APPLICATION NO. 03-02149	PROJECT NO. 1003009
PROJECT NAME JEFFERSON COMMONS JOHNNY & CARINOS	
EPC APPLICATION NO.	
APPLICANT / AGENT TIERRA WEST	PHONE NO. 858.3100
ZONE ATLAS PAGE F-17	
(SDP for SUB), (SDP for BP), (FINAL PLATS), (MASTER DEV PLAN), (IR), (AA)	
<b>ONE STOP COMMENT FORM LOG</b>

DRB Application No.: 03-02149  
Project Name: Jefferson Commons  
EPC Application No.: \_\_\_\_\_  
Phone No.: 858-3100

**TO:** Sheran Matson, DRB Chair  
**FROM:** Carmen Marrone, Staff Planner  
**RE:** **Project #1003009**, Site Plan for Building Permit,  
Johnny Carinos Restaurant, I-25/Jefferson NE

JEFFERSON COMMONS-II JOHNNY CARINOS	DRAWN BY MP DATE 12-15-2003
	SITE PLAN FOR BUILDING PERMIT	2395SPRPb-102403.DWG
TERRA WEST, I.L.C. 8509 JEFFERSON NE ALBUQUERQUE, NEW MEXICO 87113 (505)858-3100		SHEET # 1 OF 6
RONALD R. BOHANNAN P.E. #7868		JOB # 230095

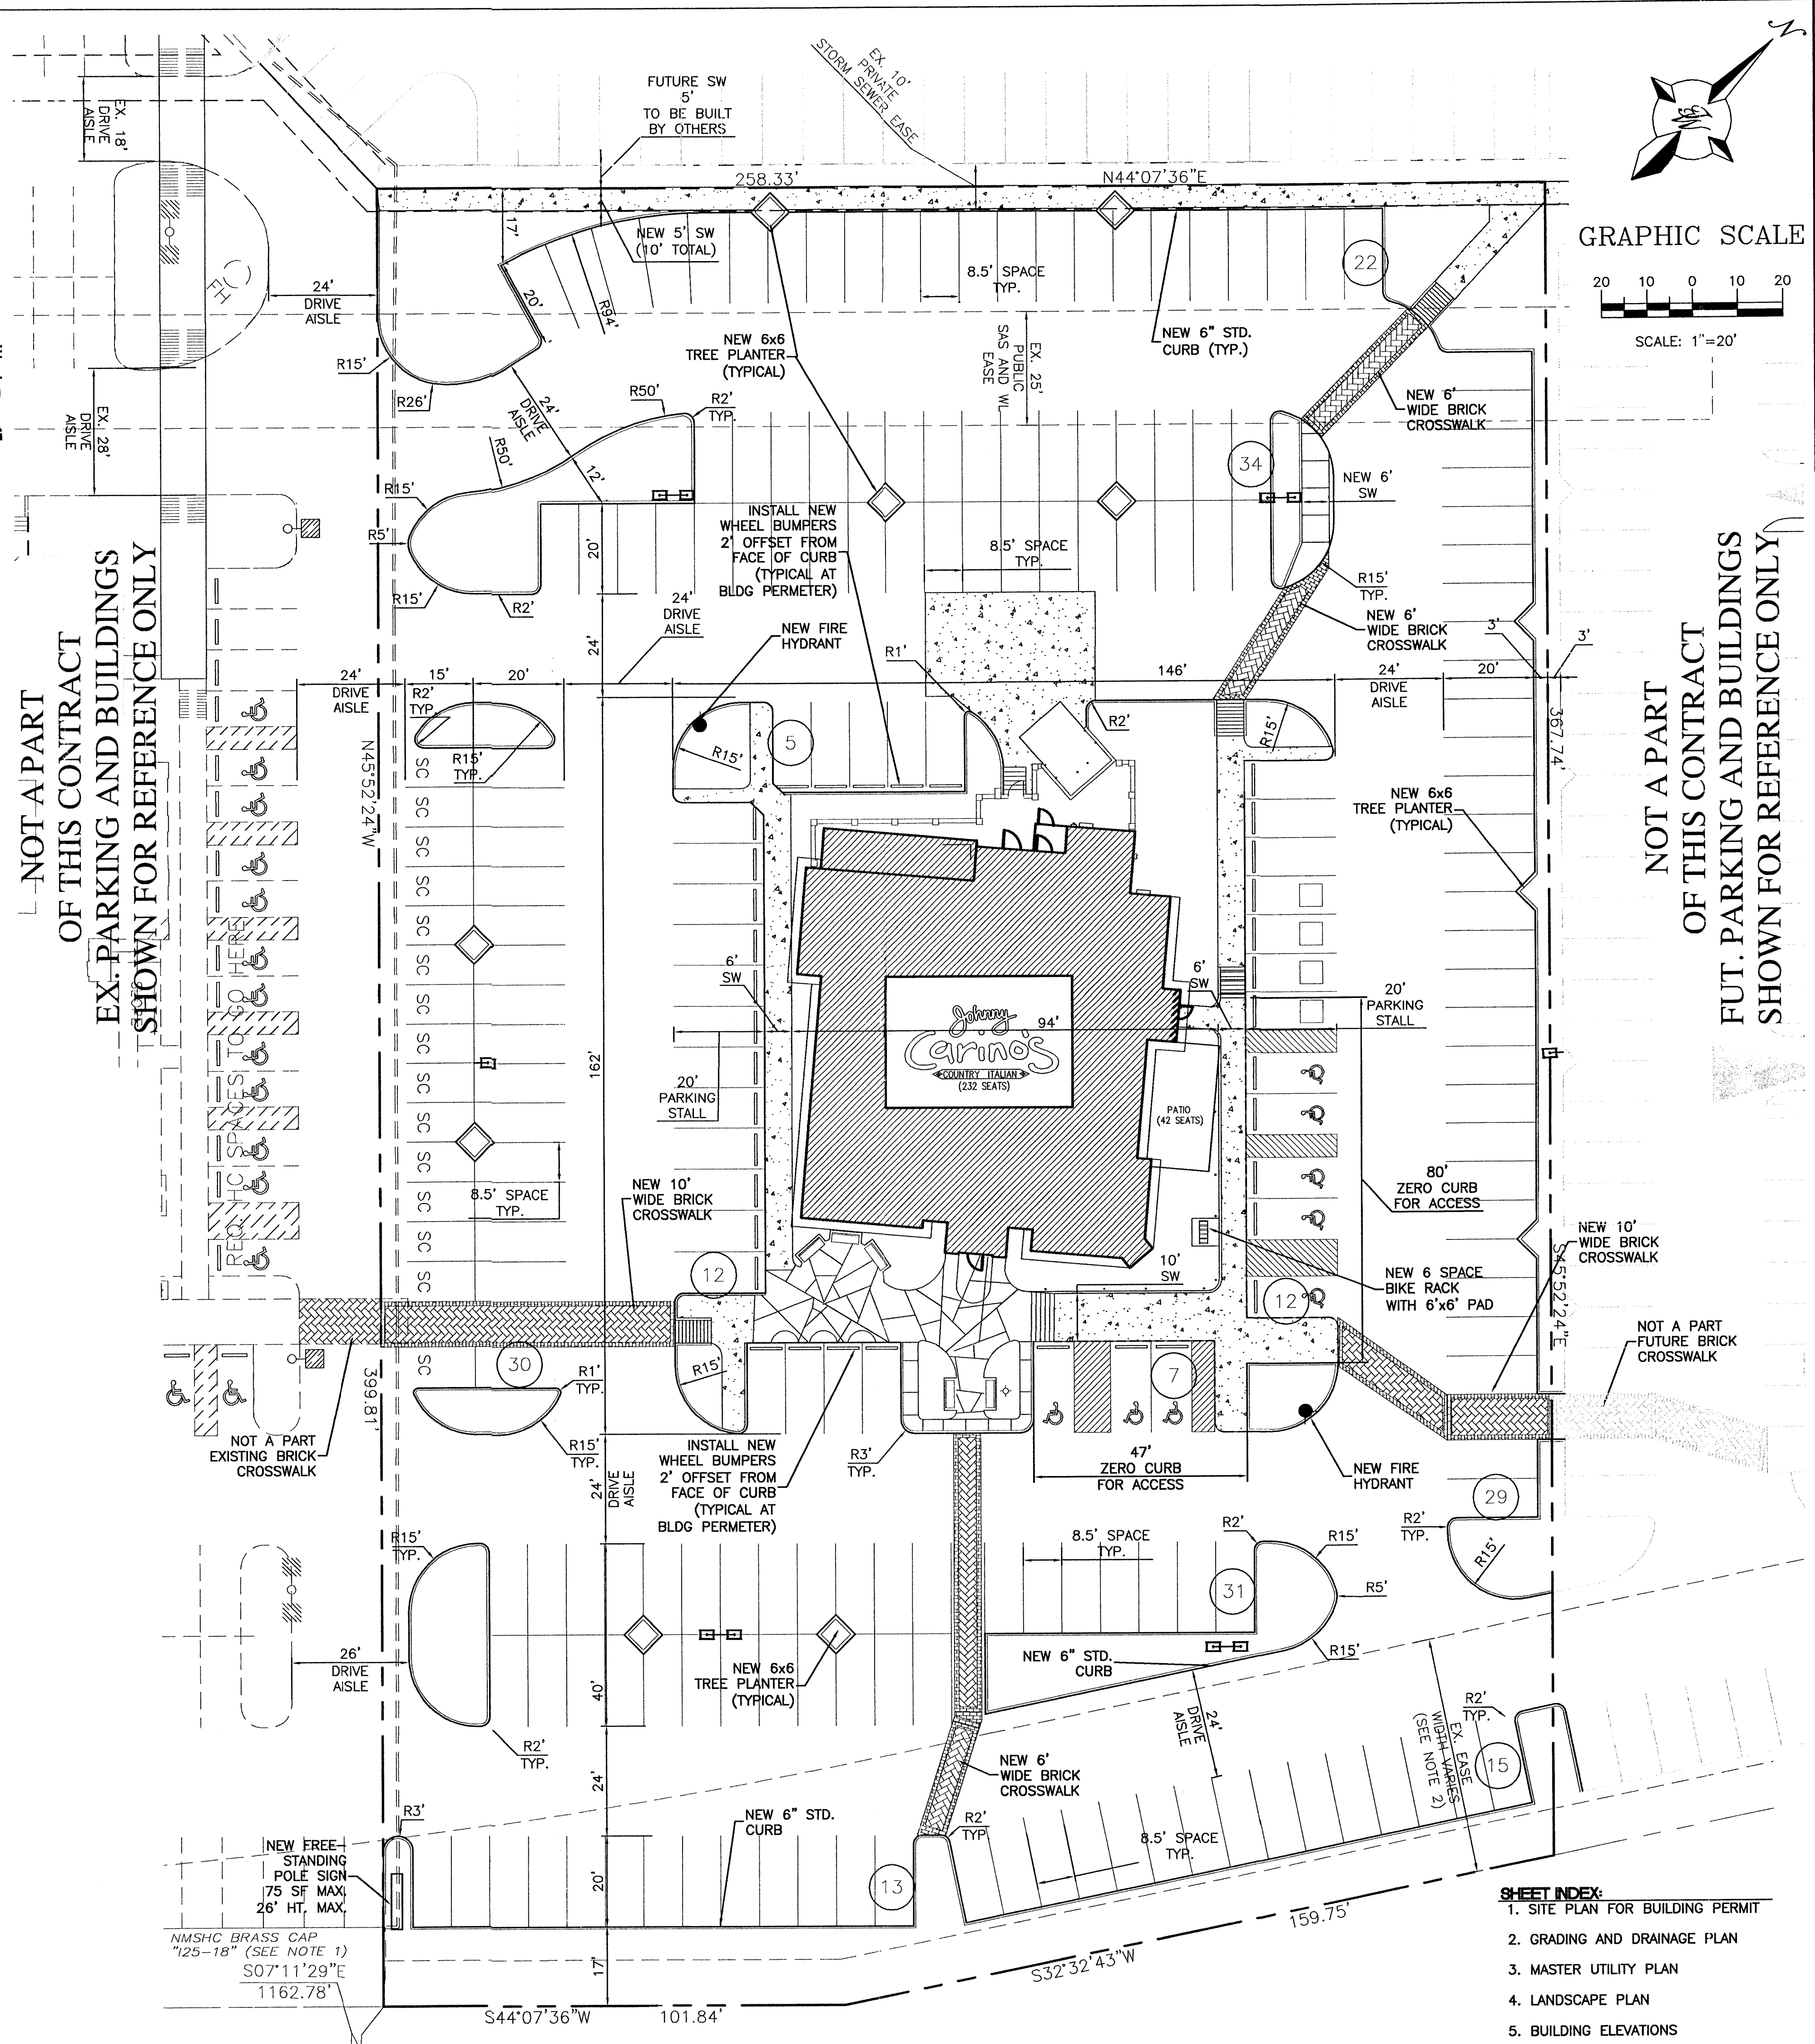
TRANSPORTATION: Dispersing of ADA spaces WF

TRANSPORTATION: DIMENSIONING of ADA SPACES  
 RADII ETC  
 \_\_\_\_\_  
 PLANT LIST  
 \_\_\_\_\_

ENGINEER'S SEAL 	JEFFERSON COMMONS - II JOHNNY CARINO'S 5011 PAN AMERICAN FRWY. NE	DRAWN BY MP DATE 12-15-2003
	MASTER UTILITY PLAN	2395MUB-102403X.DWG
TERRA WEST, LLC 8509 JEFFERSON NE ALBUQUERQUE, NEW MEXICO 87113 (505)858-3100		SHEET # 3 OF 6
RONALD R. BOHANNAN P.E. #7868		JOB # 230095

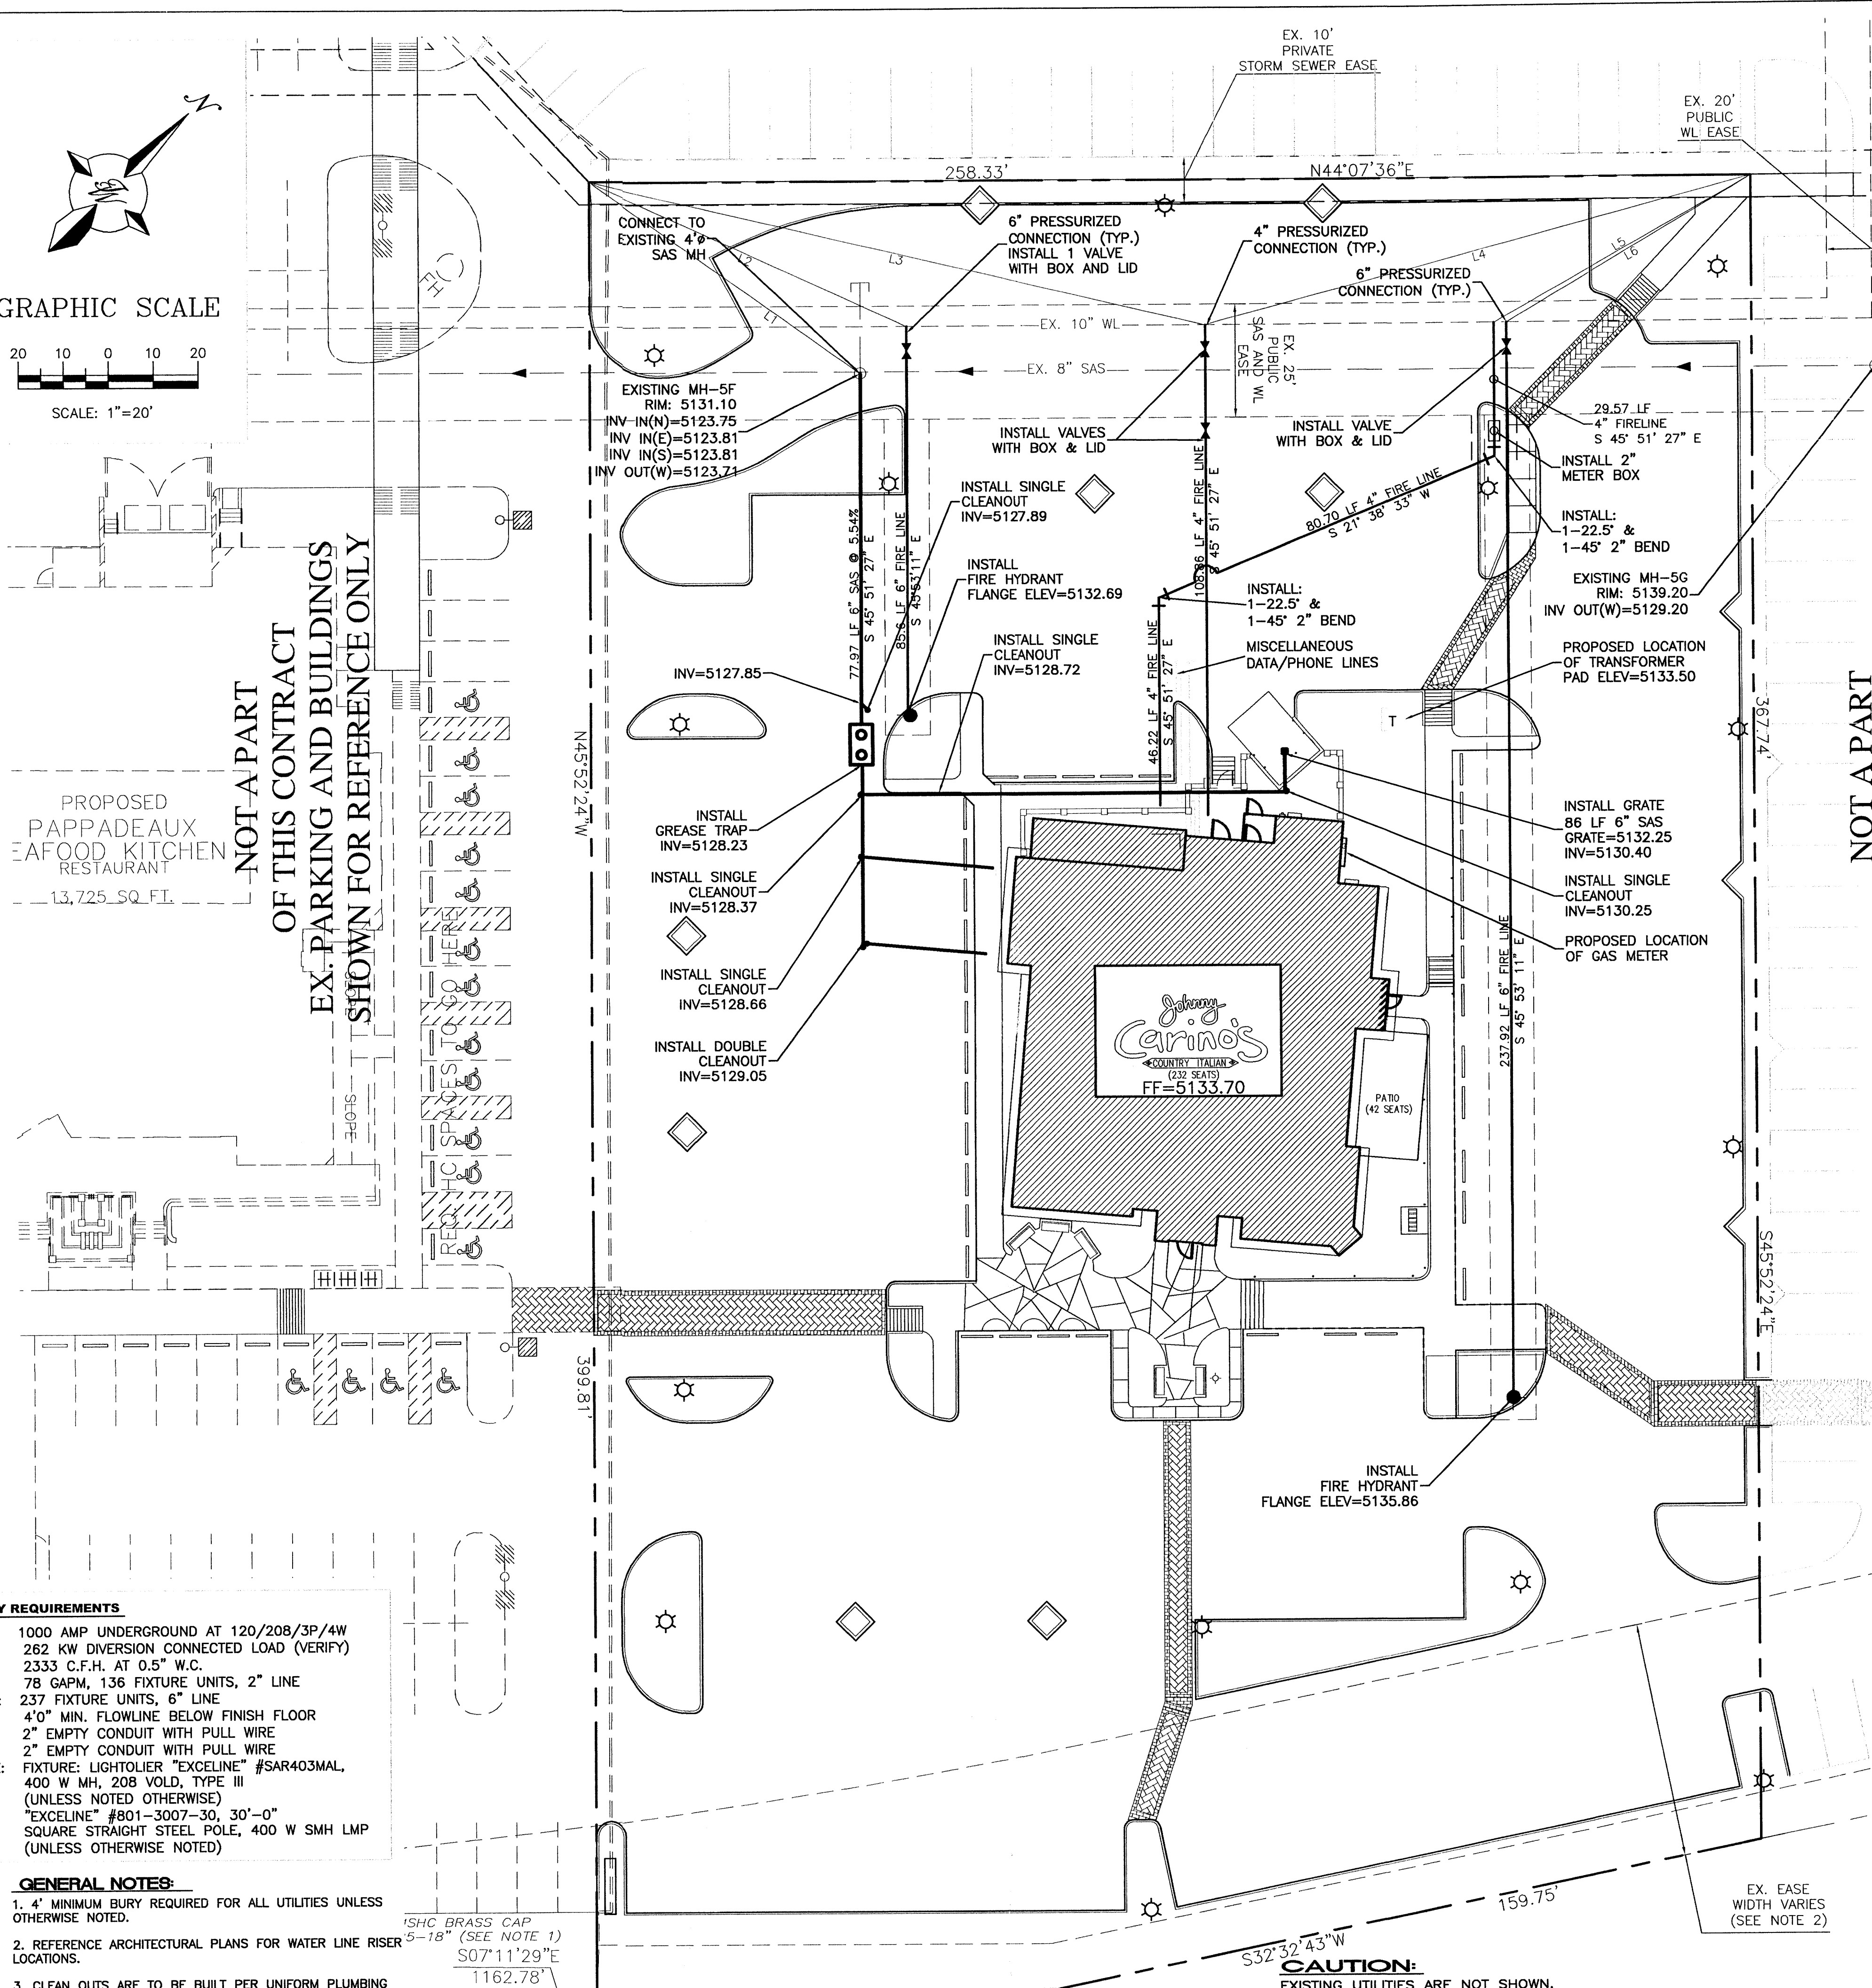
UTILITIES: Need to revise utility plan accordingly.

UTILITIES:  
 Marked up Utility Plan provided to consultant.  
 Need to revise Utility Plan accordingly.  
 \_\_\_\_\_  
 \_\_\_\_\_
